# V1\_Drainage Letter\_comments.pdf Markup Summary

## Amo Acres Subdivision

Final Drainage Report

PCD File No: **SF2623**

DRAINAGE MAP

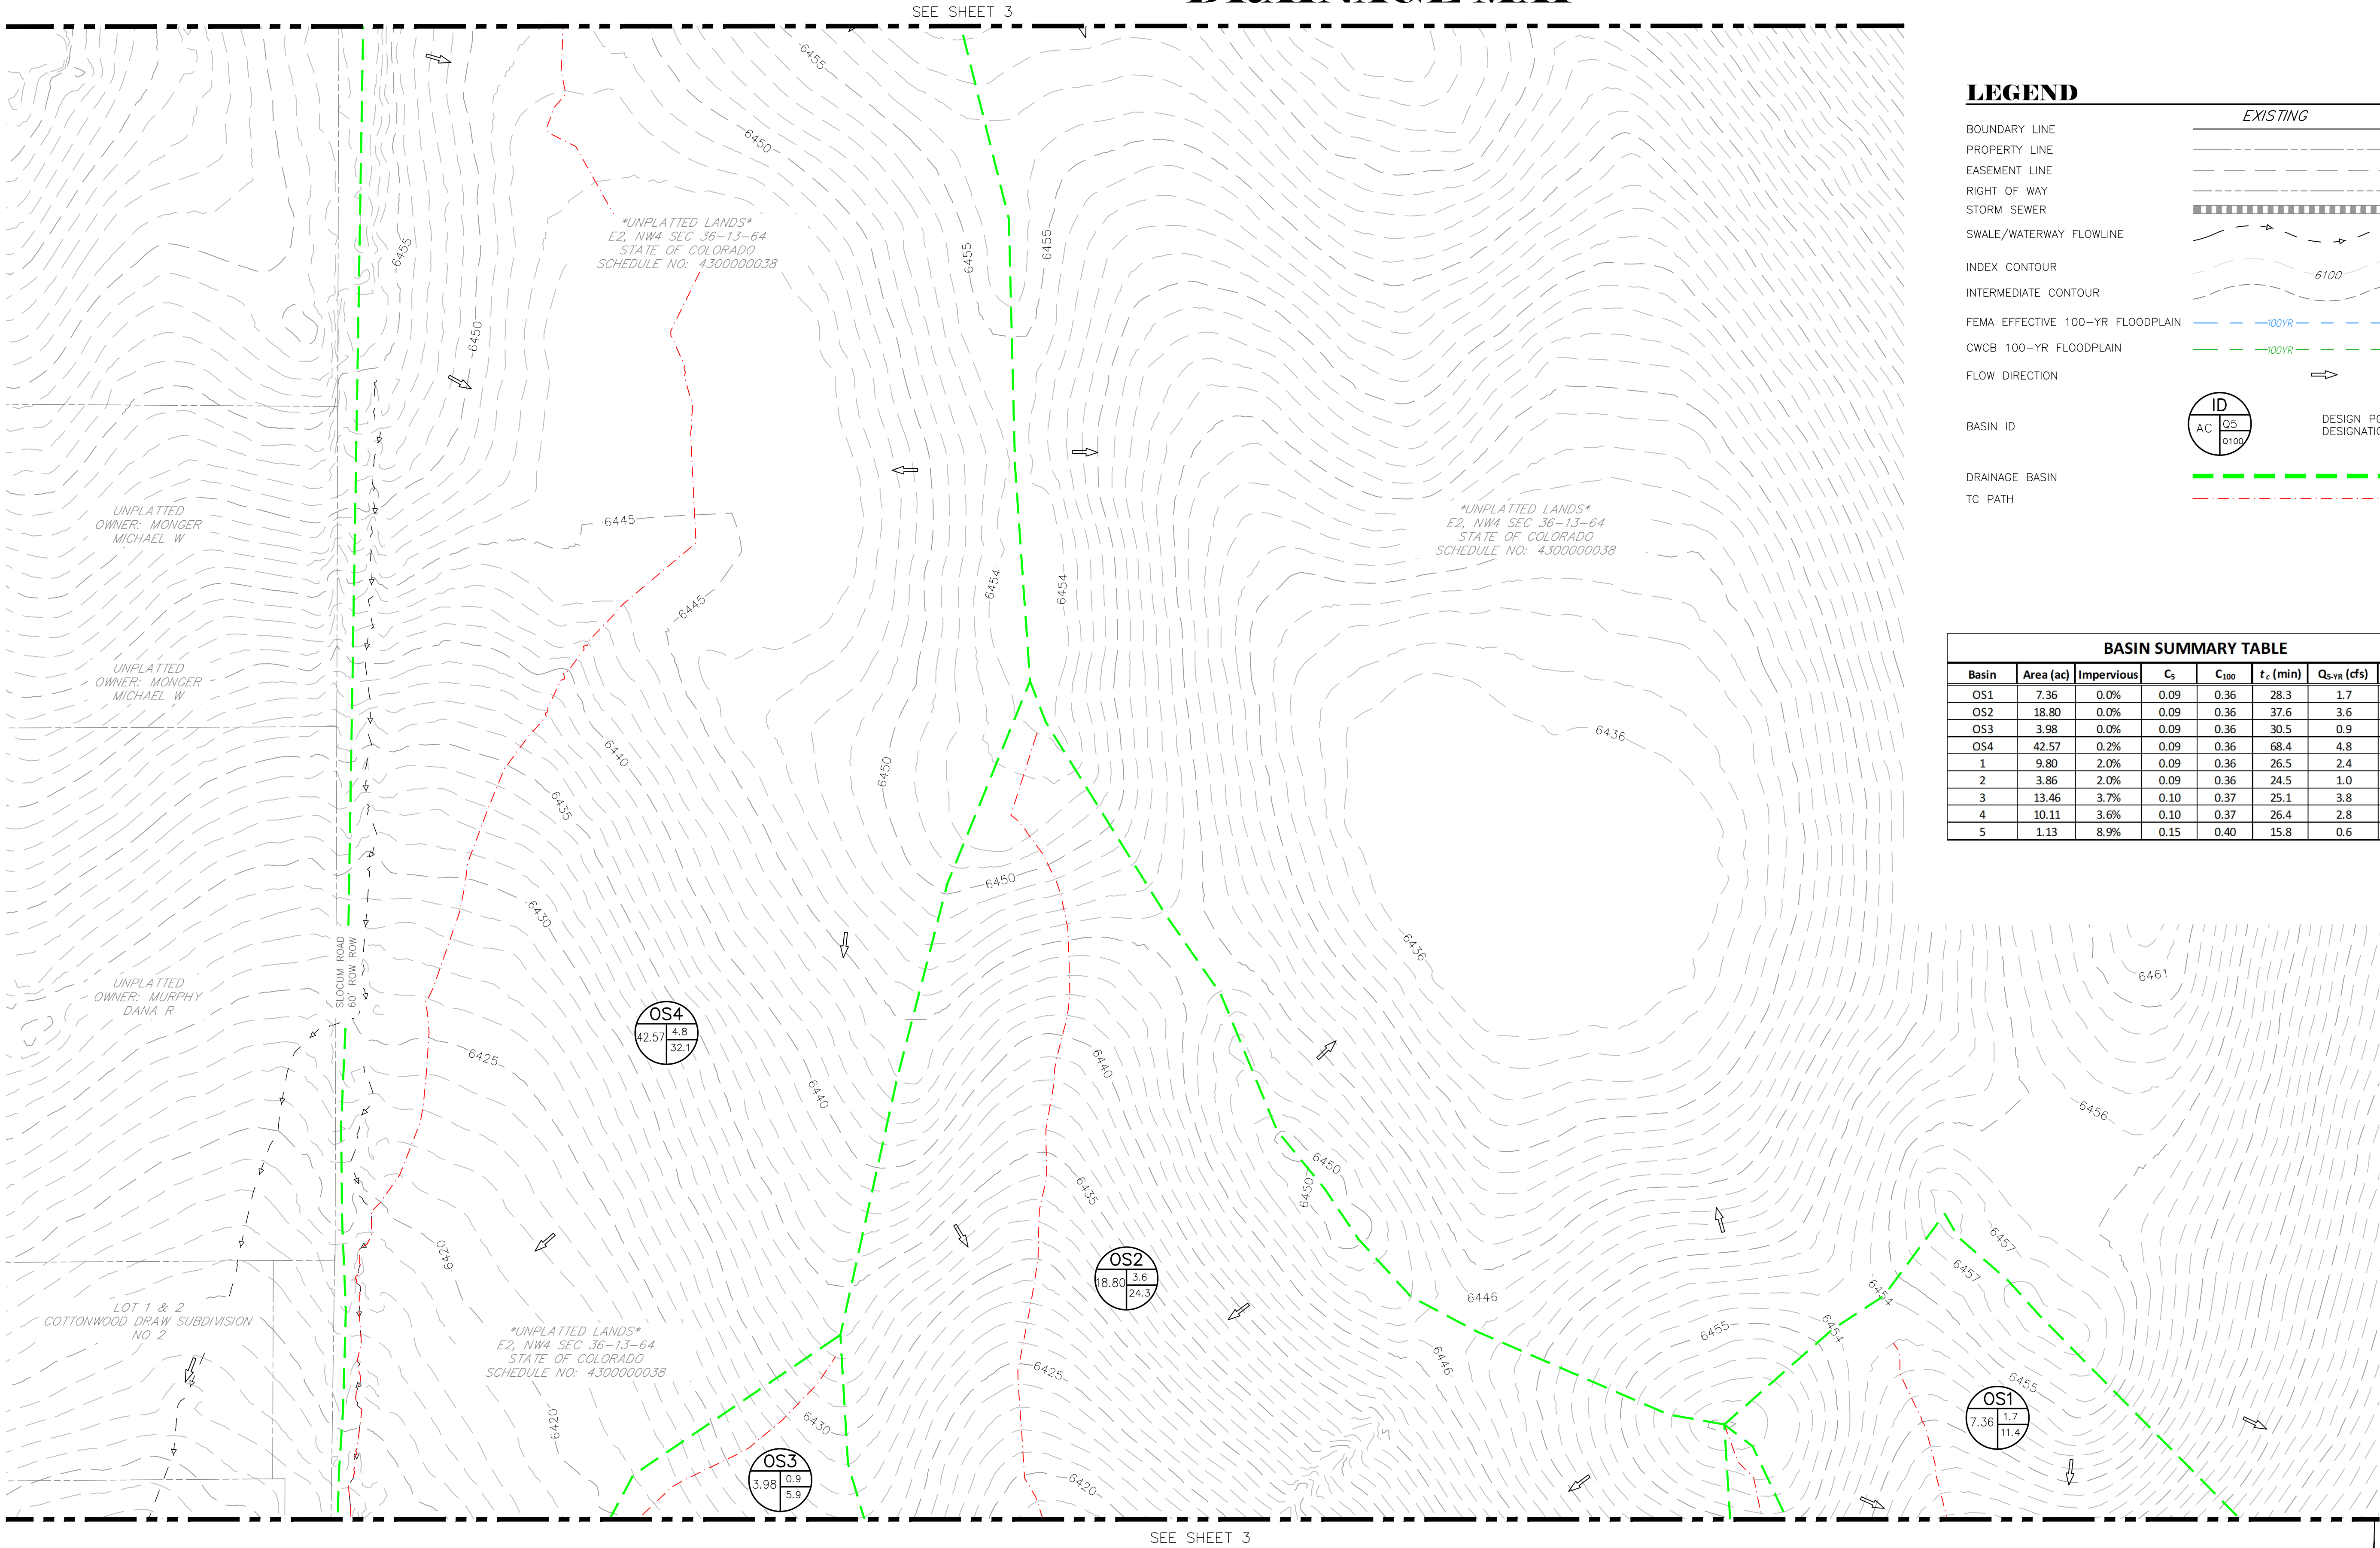
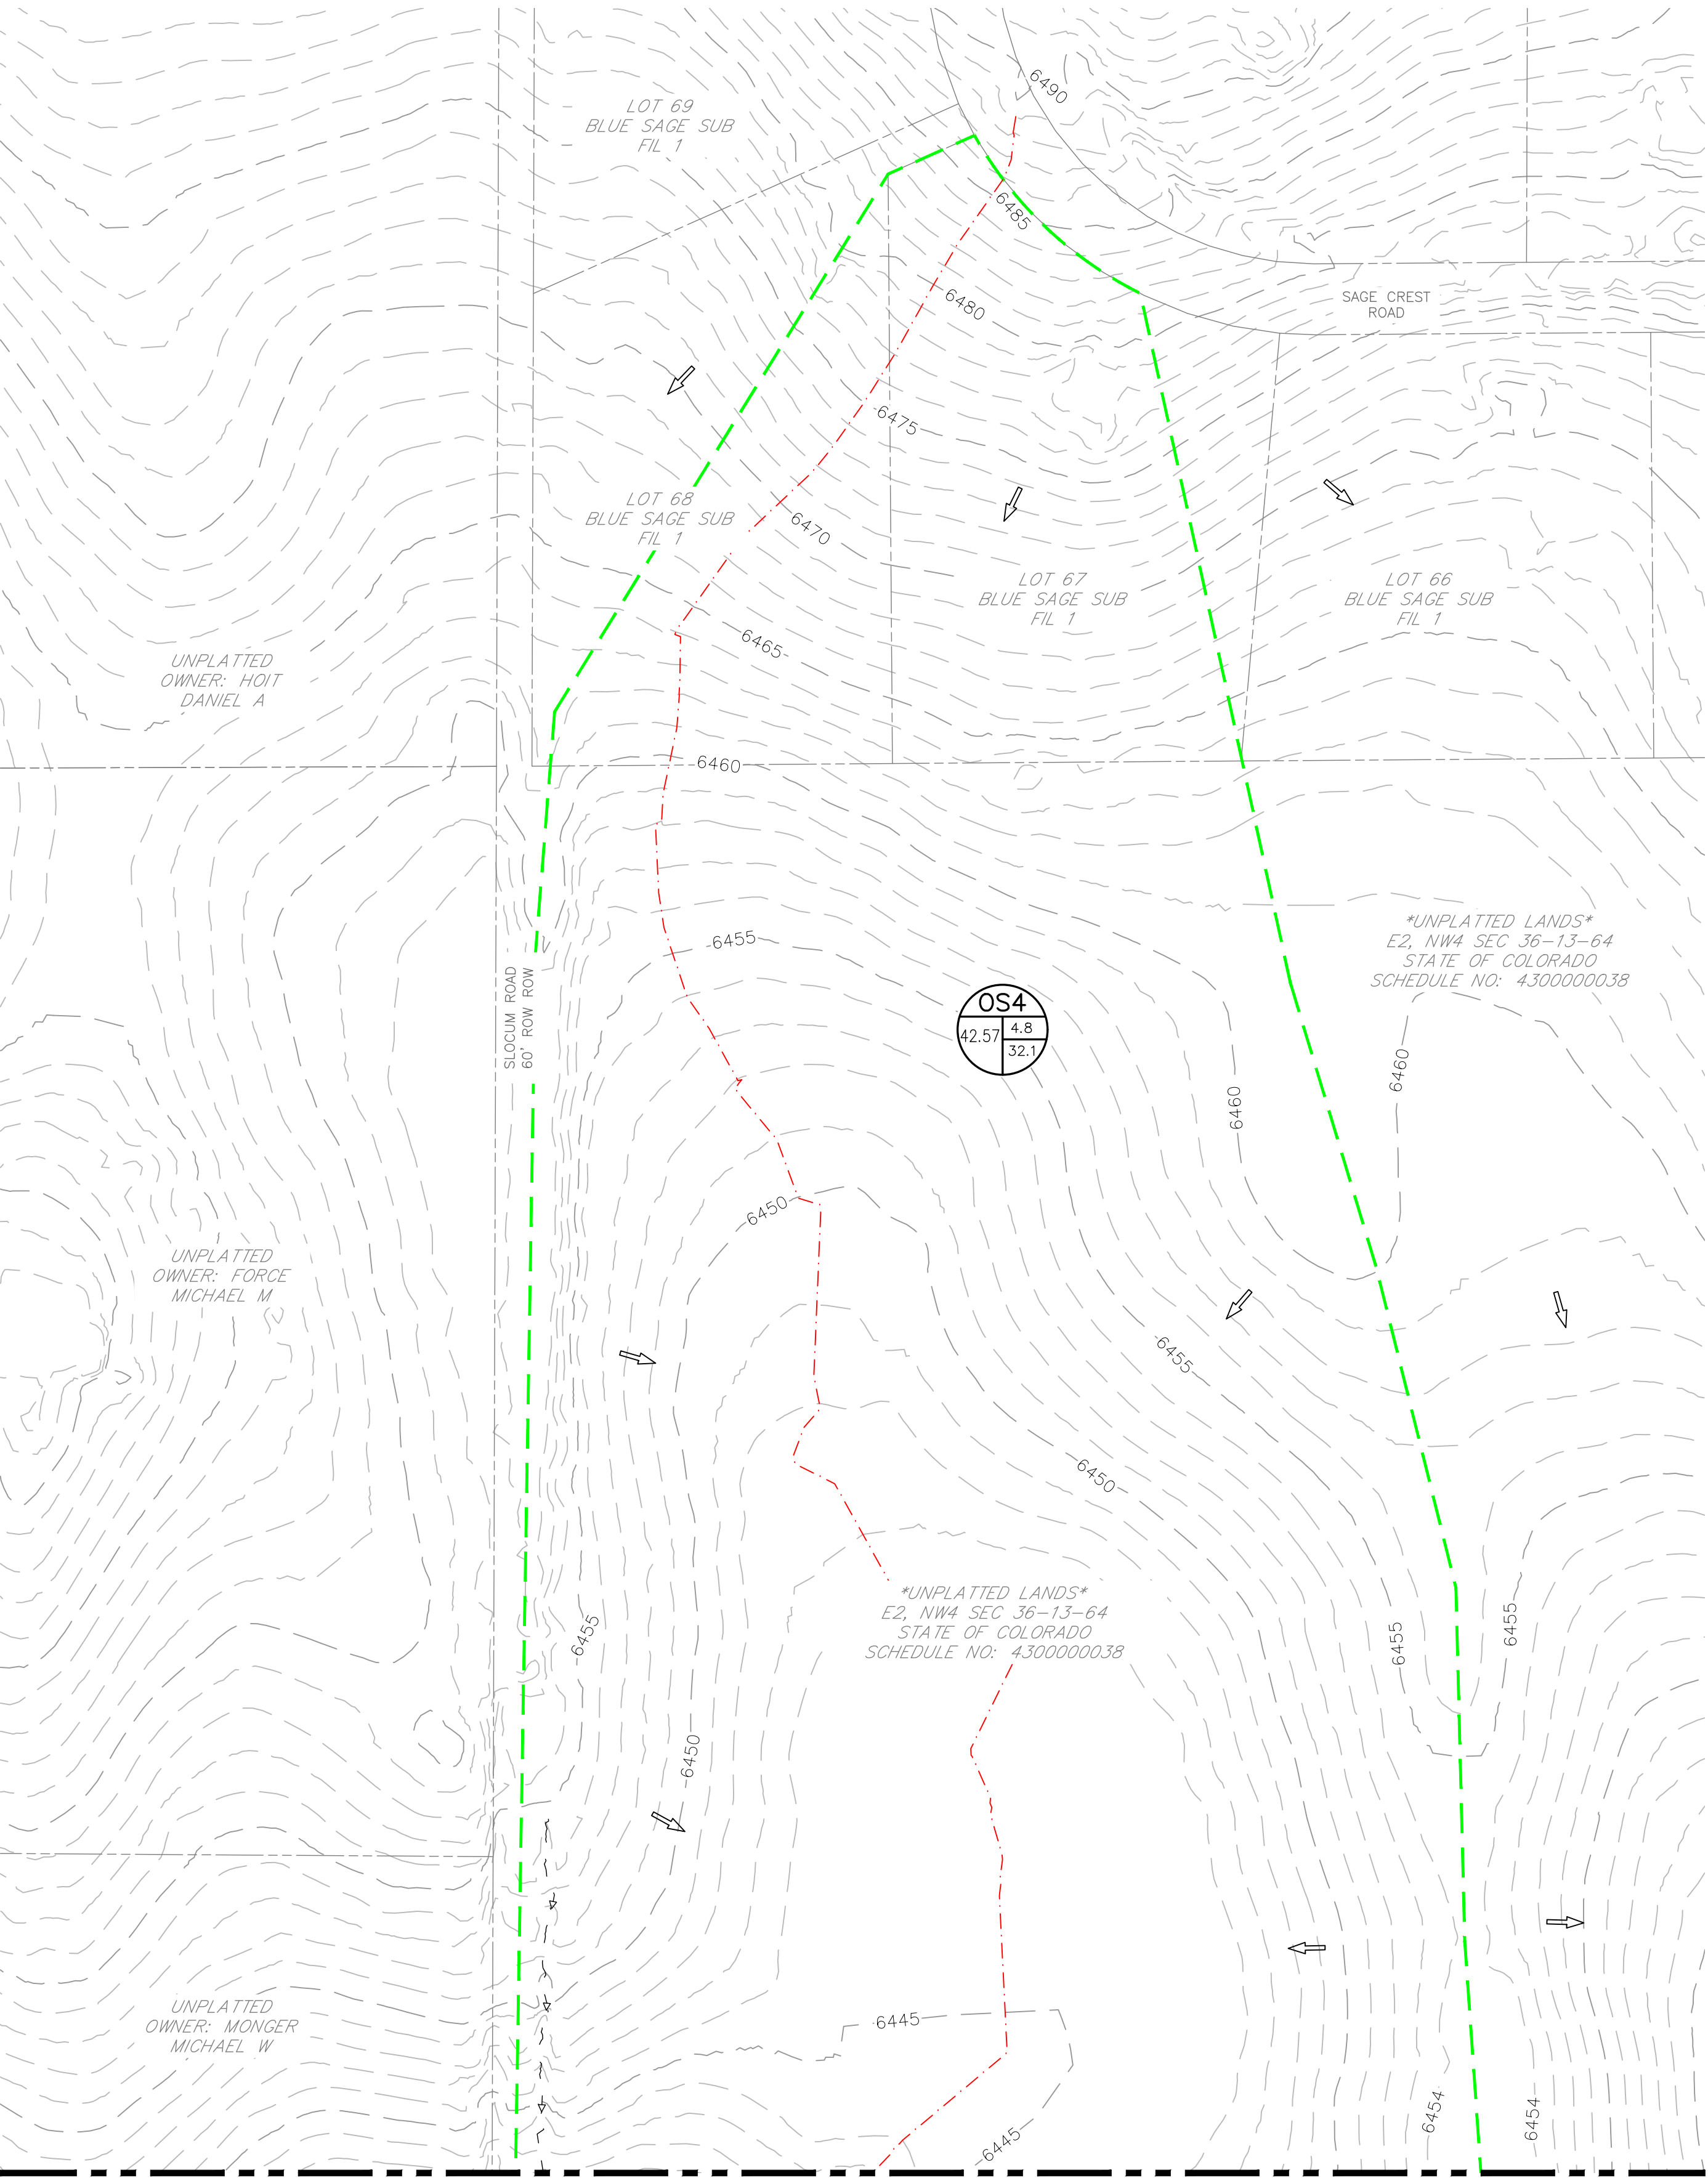
Please verify this value, is it 10.53 from pdf page 34 of 36.

Please verify this value.

ATE: Addressed. Calcs & map in appendix b & f updated accordingly.

ATE: Addressed. Calcs & map in appendix b & f updated accordingly.
